# **Martin Place, Over Station Development, North Site**

## **Architectural Design Statement**

**22/04/22**

This Architectural Design Statement has been prepared as an accompanying document to the submission of a S4.55 Application. The following changes are proposed:

Drawing Title
SYDNEY METRO-MARTIN PLACE EAST ELEVATION GENERAL ARRANGEMENT
Status
STAGE 5
Drawing Number
CSWSMP-MAC-SMN-AT-DRG-DA-409900
Revision
0

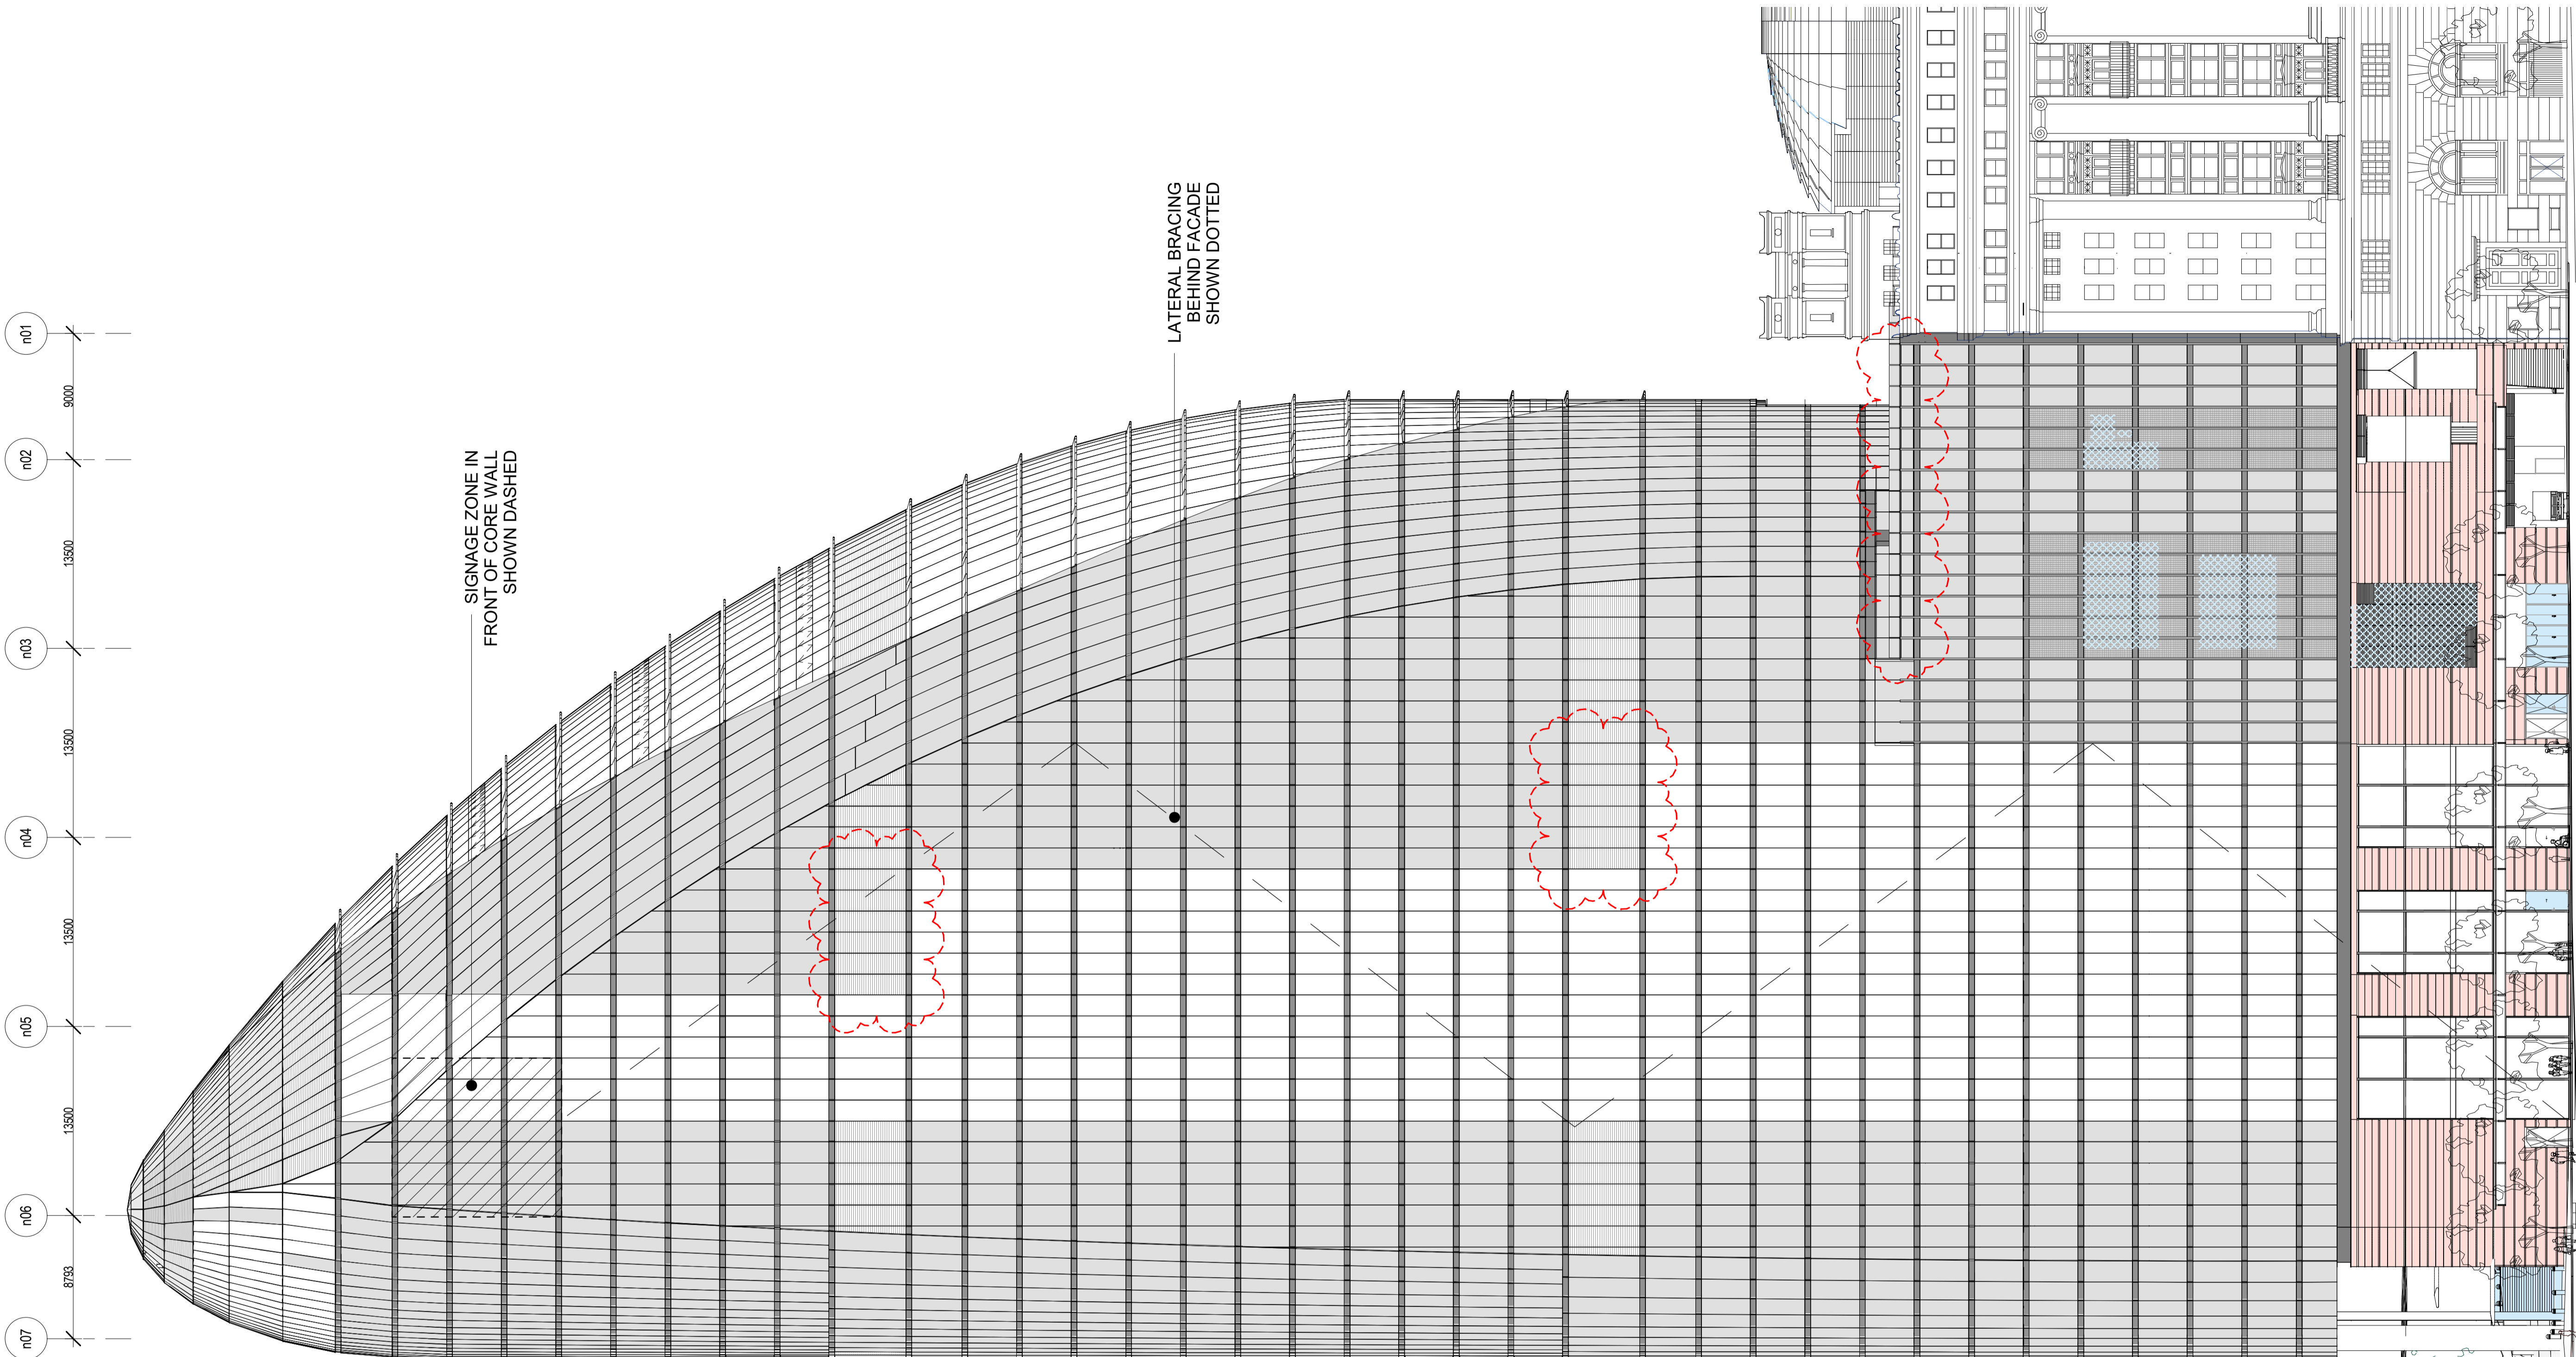
During design development the client instructed an increase in height of the terrace balustrade to 1800mm. The approved facade parapet height and alignment to 50 Martin Place is maintained.

- Client fitout requirements have necessitated the addition of new kitchen exhaust louvres on L11. These louvres are located within the existing recessed aluminium spandrel zone of the facade panels and make minimal difference to the facade appearance and presentation of the building.
- The substation removal hatches on L15 and L28 have been reduced in size.
- Generator flue requirements have been clarified for L28. These were previously not shown on the approved DA drawings and they are now shown. The flues are integrated into the facade louvre panels and have been coordinated to be located centrally within the louvre panels. They do not project beyond the facade line. They are detailed to finish flush with the face of the louvres.
